# CITY OF ALBUQUERQUE

October 19, 2017

RE: **4936 Pan American  
Grading and Drainage Plan  
Engineer's Stamp Date 10/11/17  
Hydrology File: F17D032**

DATE	10/11/2017	SHEET	C1.1
SCALE	AS NOTED	OF	2

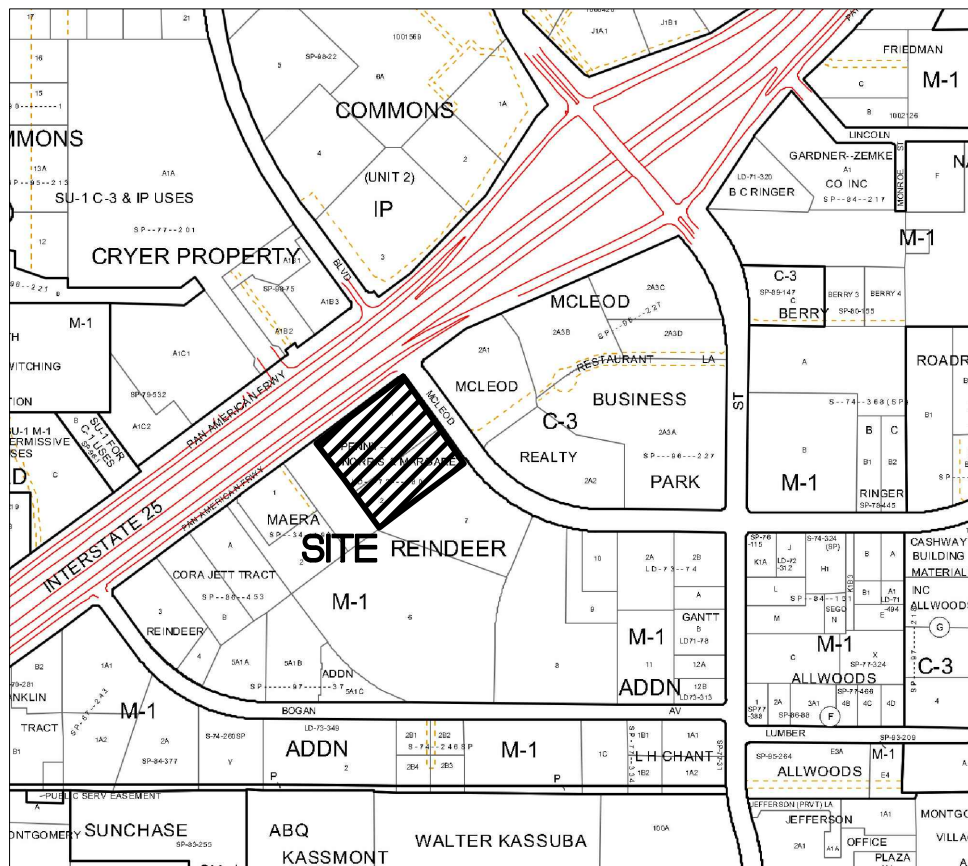
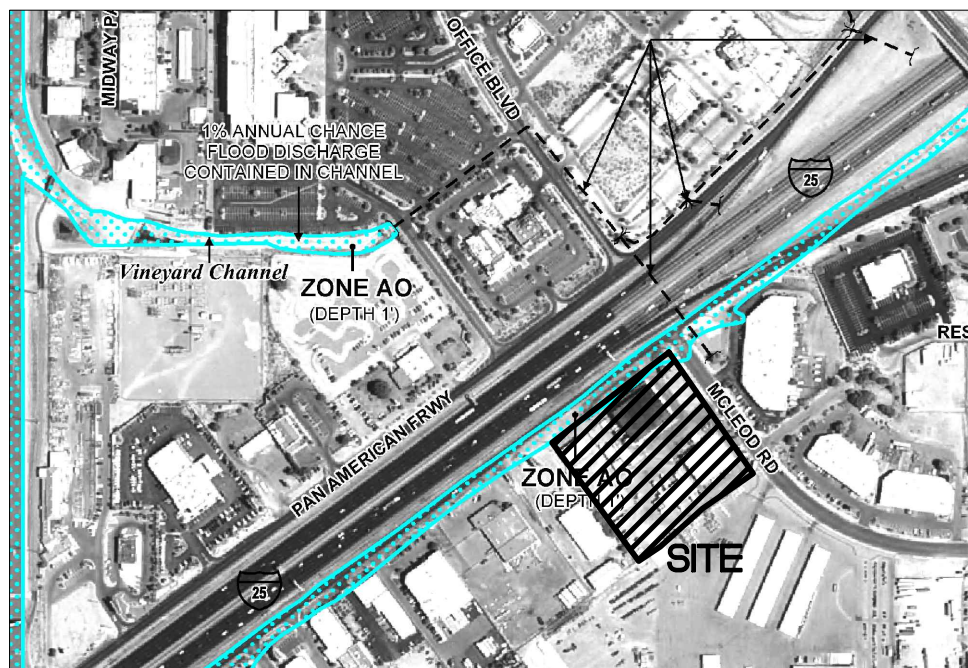
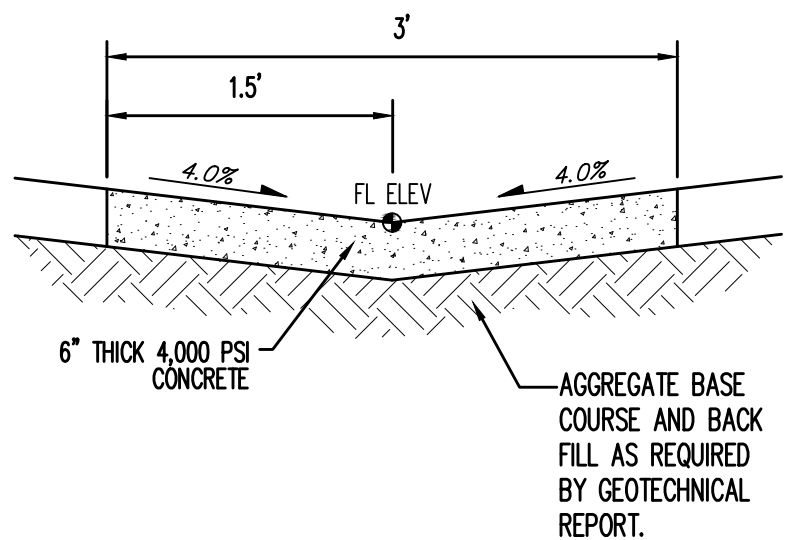
3. How much fill/cut is being placed in the floodplain?
4. No increased runoff to overcapacity systems (floodplain) can be authorized per § 14-5-2-12 (10)(G) of the Albuquerque Code of Ordinances. The current plan demonstrates this, however any changes need to continue to demonstrate this as well.

7. Regarding first flush volume: this site qualifies as redevelopment and is only required to retain runoff from the 80<sup>th</sup> percentile storm ( $\text{Vol.} = 0.26'' * \text{Imp. Area}$ ).
8. It is unclear how Basin C routes entirely to the curb opening. What is the cross-slope on the driveway? Is everything graded towards the curb opening?

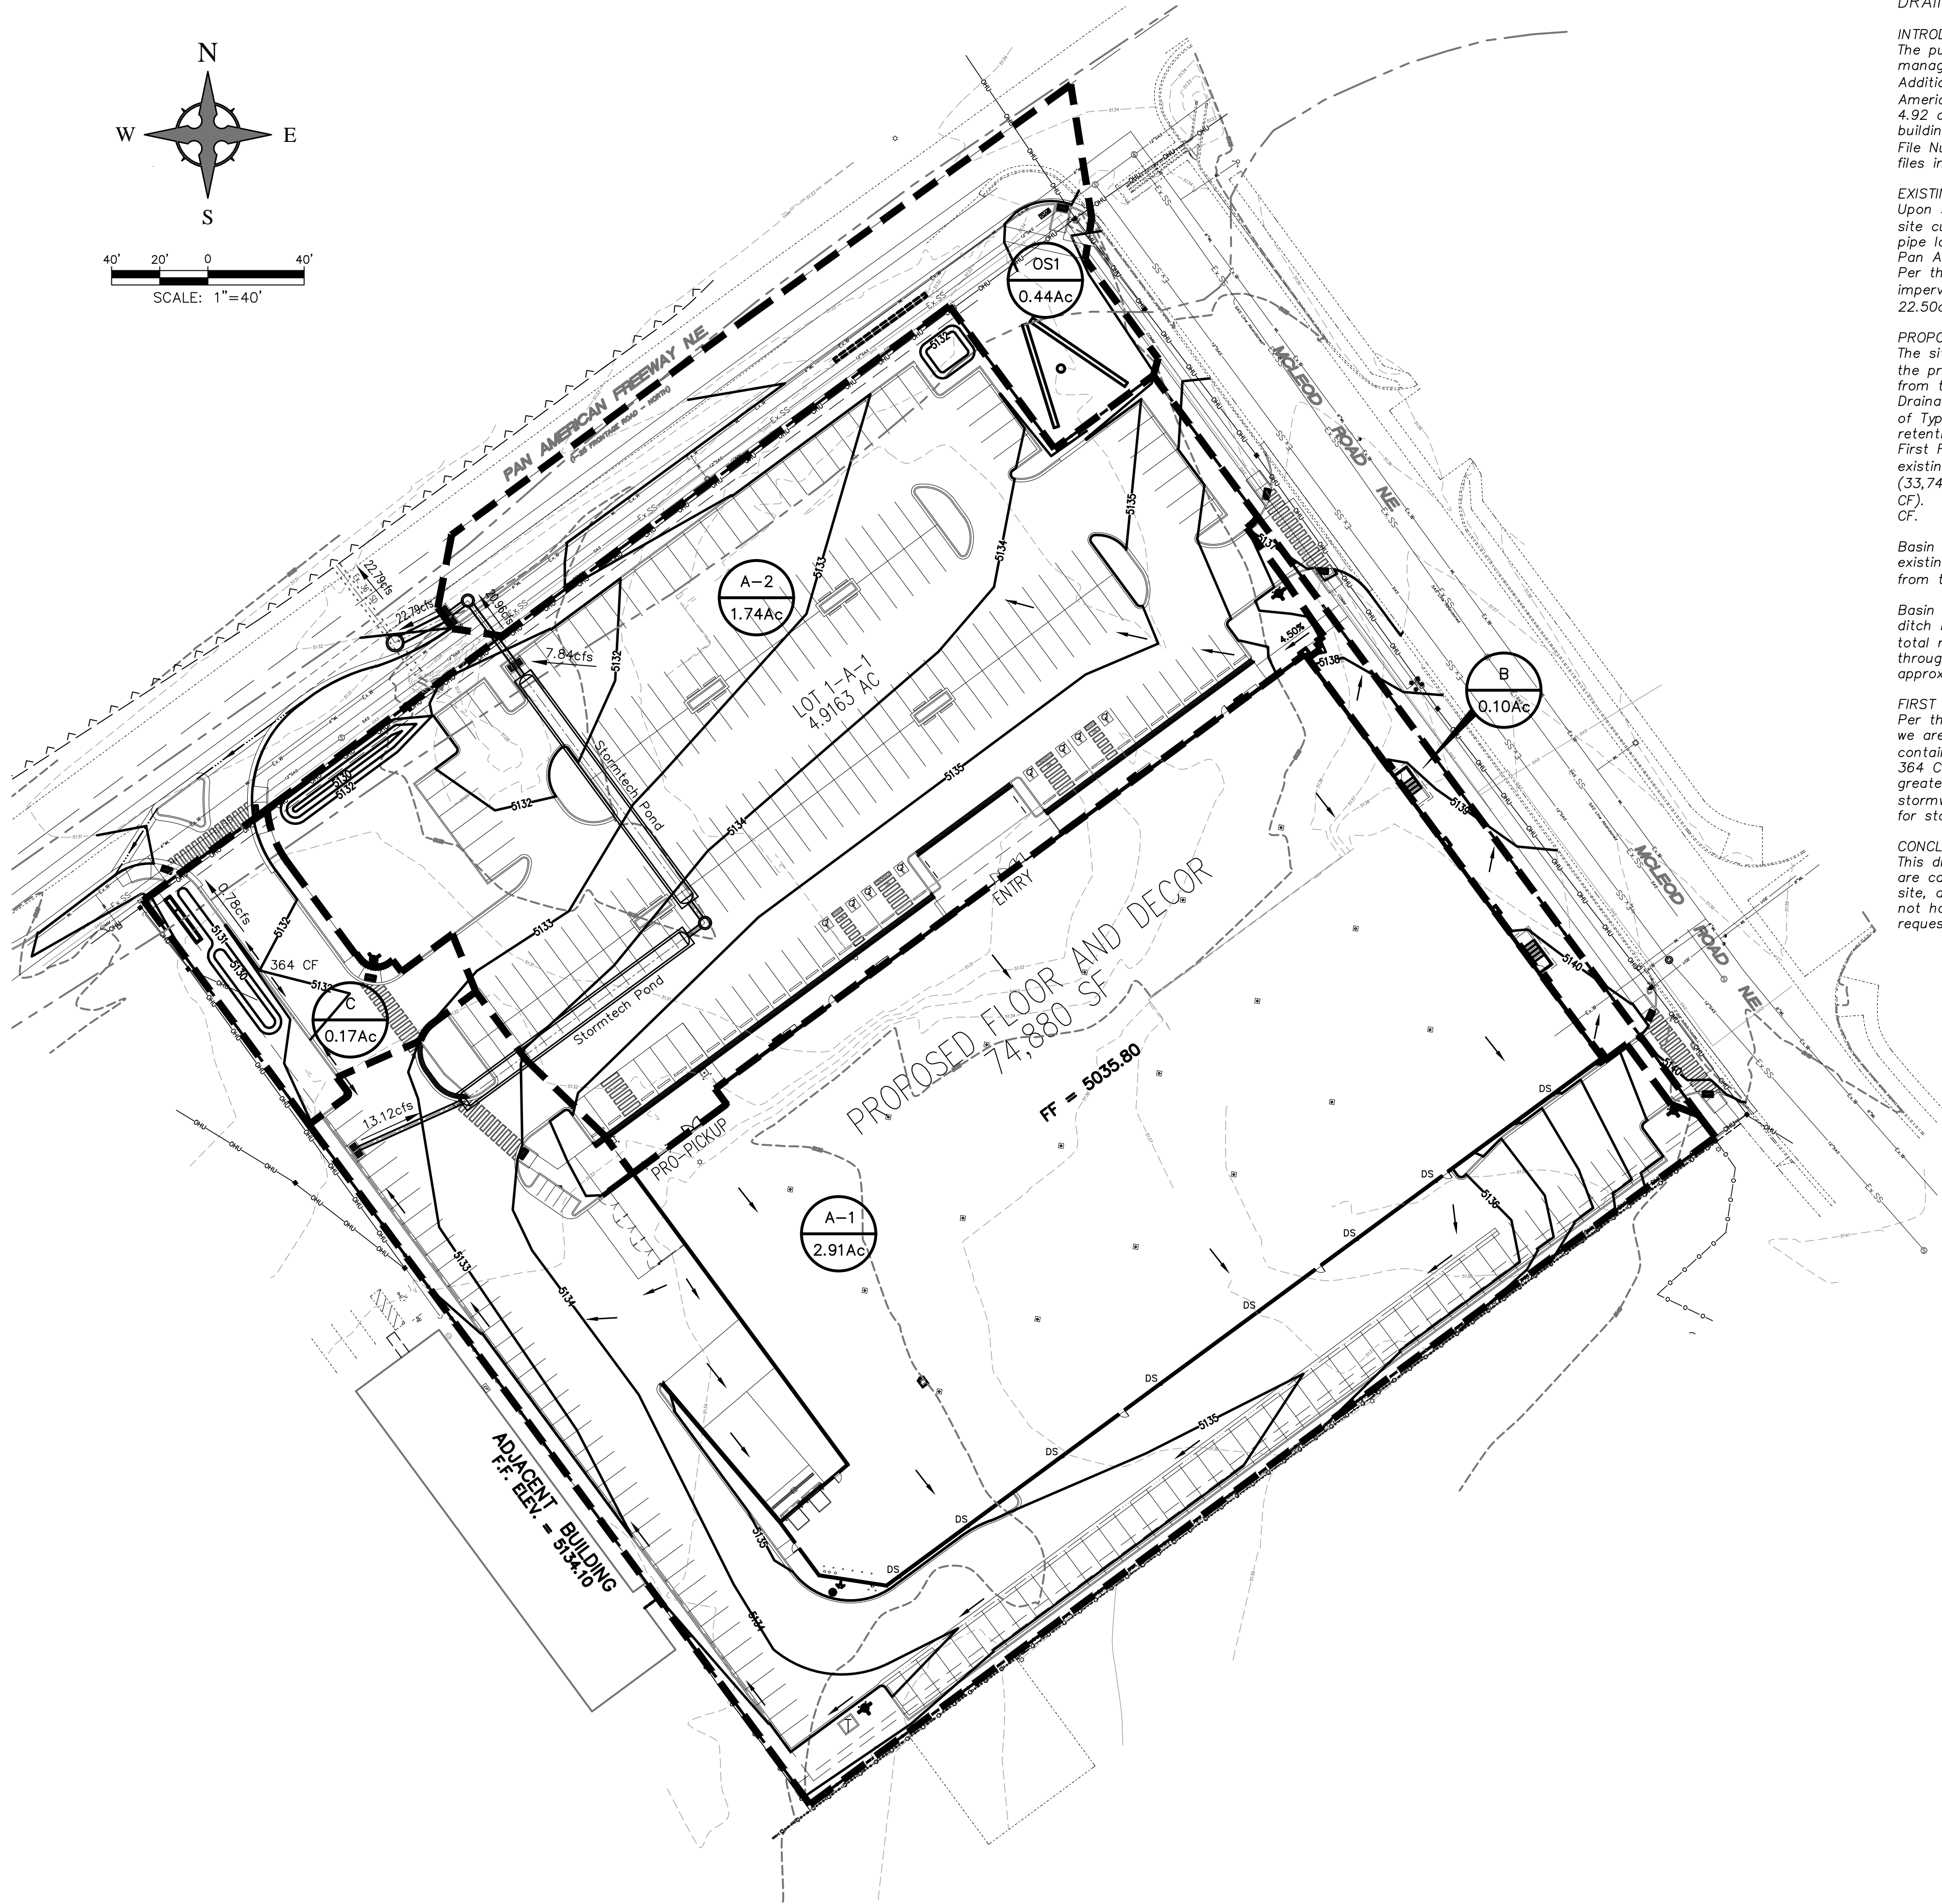
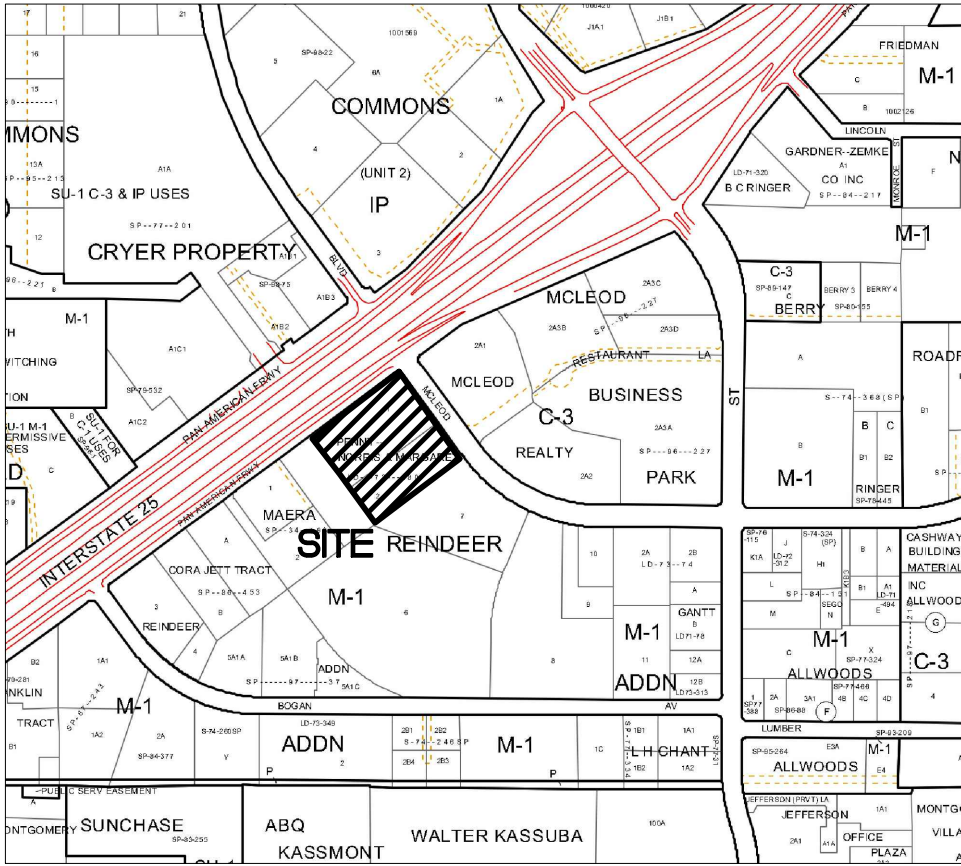
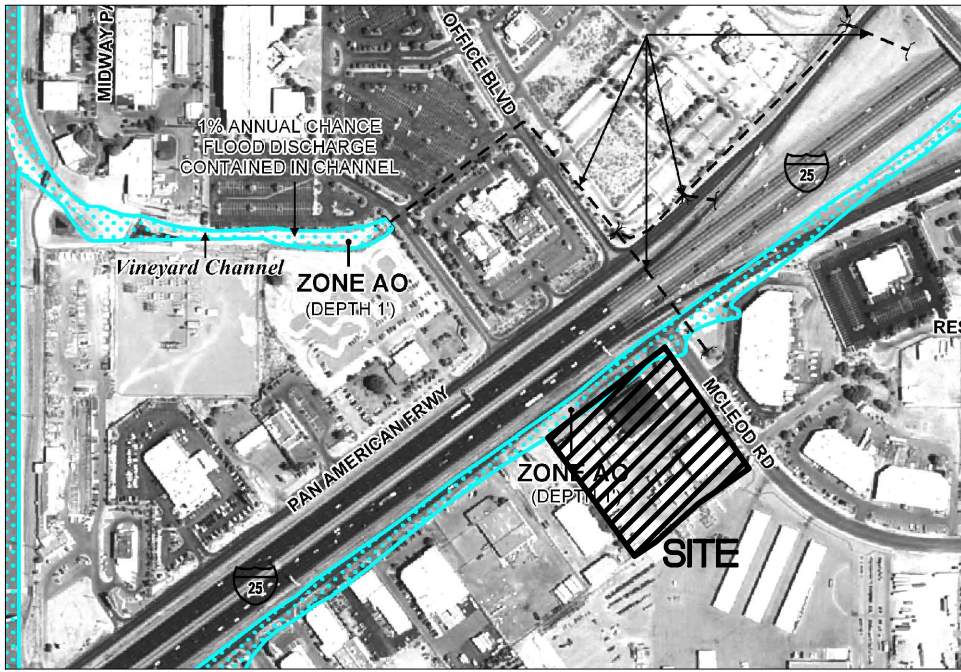
5. Provide volume calculations for the stormtech basins; the City allows only 30% void space for the gravel bedding.
6. Quantify the first flush volume that bypasses first flush facilities. It appears that Basin B and most of Basin C bypass.

9. Payment in Lieu is required for the first flush bypass volume (\$8.00/CF).
10. How does the roof drain? Include clarifying language, flow direction, soffits, gutters, etc...
11. A Private Facility Drainage Covenant is required for the stormwater quality ponds/stormtechs. The original notarized forms, exhibits, and recording fee (\$25, payable to City of Albuquerque) must be turned into DRC (4th, Plaza del Sol) for routing. Please contact Charlotte LaBadie (clabadie@cabq.gov, 924-3996) or Madeline Carruthers (mtafoya@cabq.gov, 924-3997) regarding the routing and recording process for covenants.
12. Water quality inlets are recommended at the inlets to the stormtechs to reduce sedimentation and maintenance in the stormtechs.
